Address: 319A, Halifax Road, Liversedge, WF15 6NE

Application number: 2026/90765	
What is the application for?:	Erection of two storey side extension and detached garage with associated altera
Address of the site or building:	321, Halifax Road, Hightown, Liversedge, WF15 6NE
Postcode:	WF15 6NE

Type of comment: An objection	
Do you wish your comments to be published on the website anonymously?	No

**DRAWING TITLE**  
Site Location Plan and Proposed Site Plan

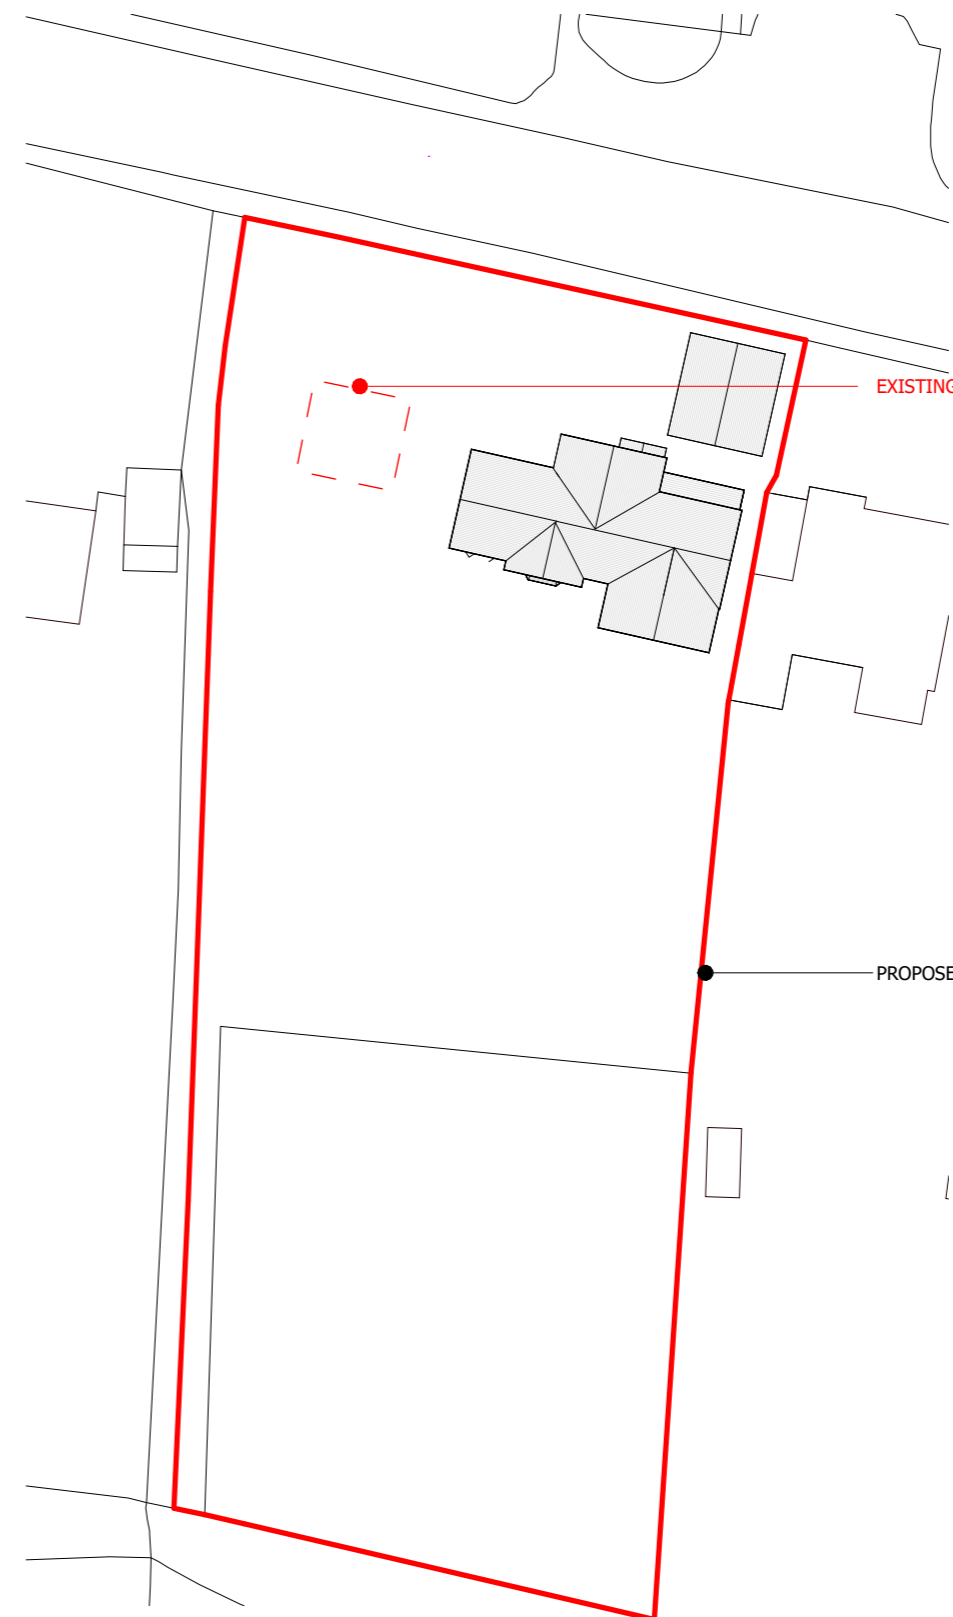
3. The proposed garage re-positioning - the applicant has provided no evidence or justification for the position of the replacement garage in front of the building line. Kirklees Supplementary Planning Document "House Extensions and Alterations" states, at paragraph 5.30, that outbuildings such as garages should "normally" be set back behind the building line of the original building so that they do not impact on the street scene. Clearly, the location of the proposed garage between the front elevation of the original building and the highway will have a considerable impact on the character and appearance of the area, and will only serve to further undermine the green belt in this location. No justification has been put forward as to why the garage needs to be in this location. The height of the garage, so close to the extension/boundary, will have a negative impact on 319A Halifax Road.
